**Christina Stacey - Re: Permit #249 - 460 St. John St.**

**From:** <tsdb1@juno.com>  
**To:** <cstacey@portlandmaine.gov>  
**Date:** 2/23/2016 9:40 AM  
**Subject:** Re: Permit #249 - 460 St. John St.

I am in the process of reviewing your permit application to replace the rear staircase and stoop at 460 St John St. I had a question - is the new stairs/stoop a different configuration than the old one? In aerial photos it looked like the old one came straight out and the new one will be tucked against the porch.

Plot Plan

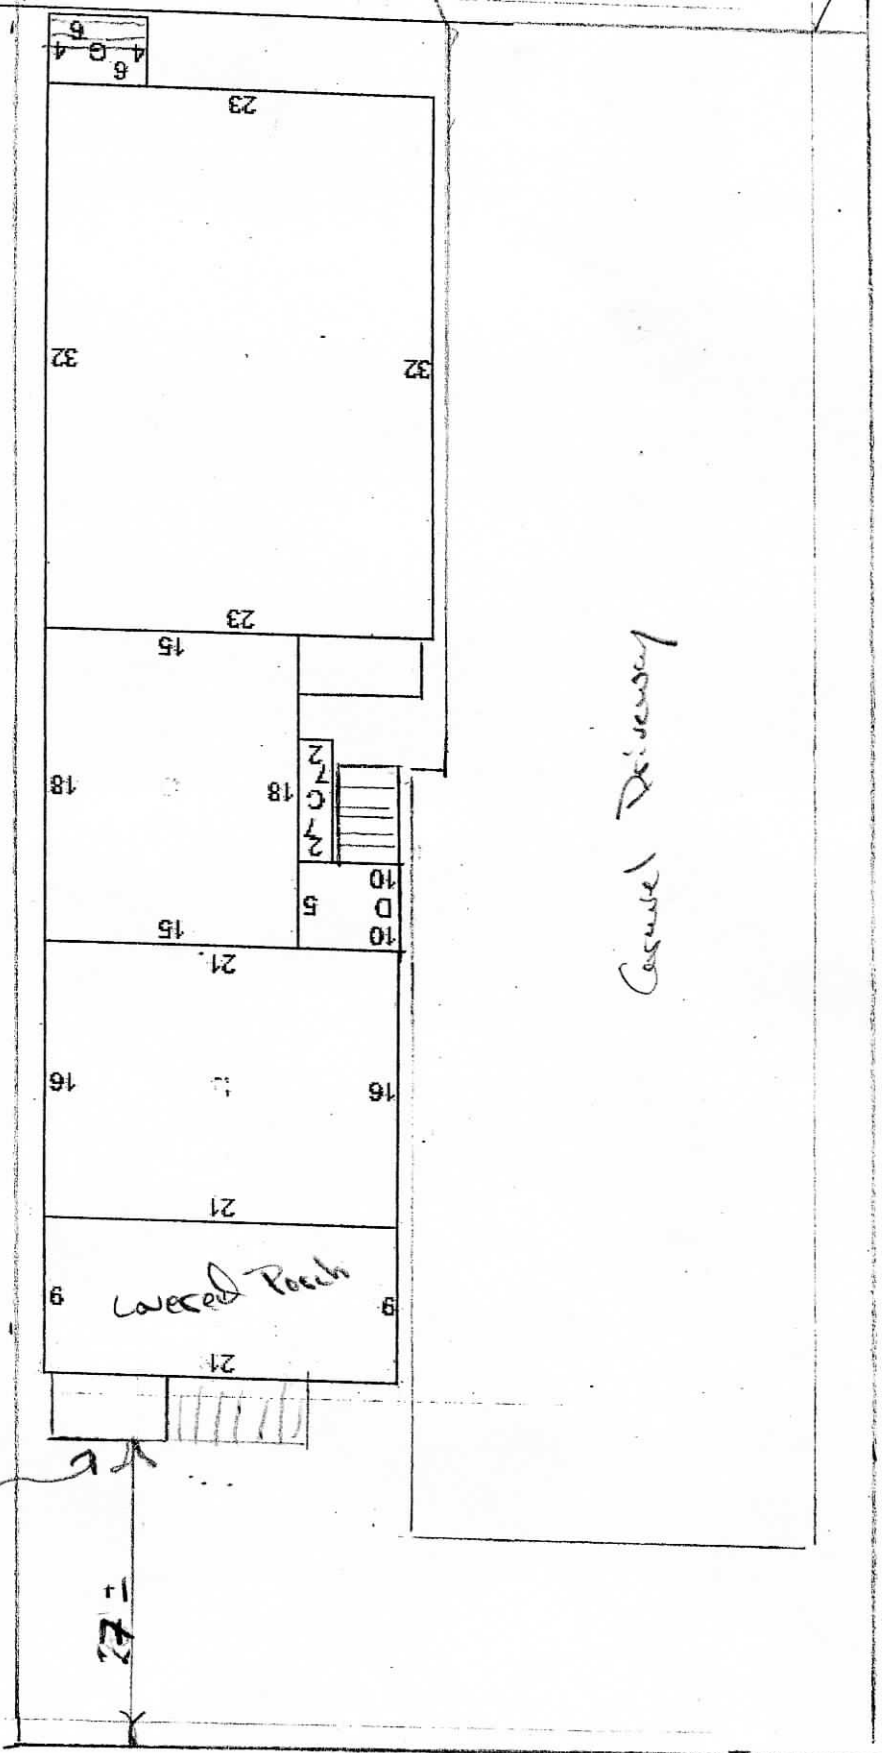
Also, can you tell me roughly what the dimensions of the new staircase will be? Scaled from the plan it appears to be about 4' by 8' but I just wanted to confirm.

Yes, the new stairs are configured to be tucked against the porch. The stoop to be approx 4x6, the staircase itself works out to between 8.5 and 9 feet in length by approx 4 feet in width.
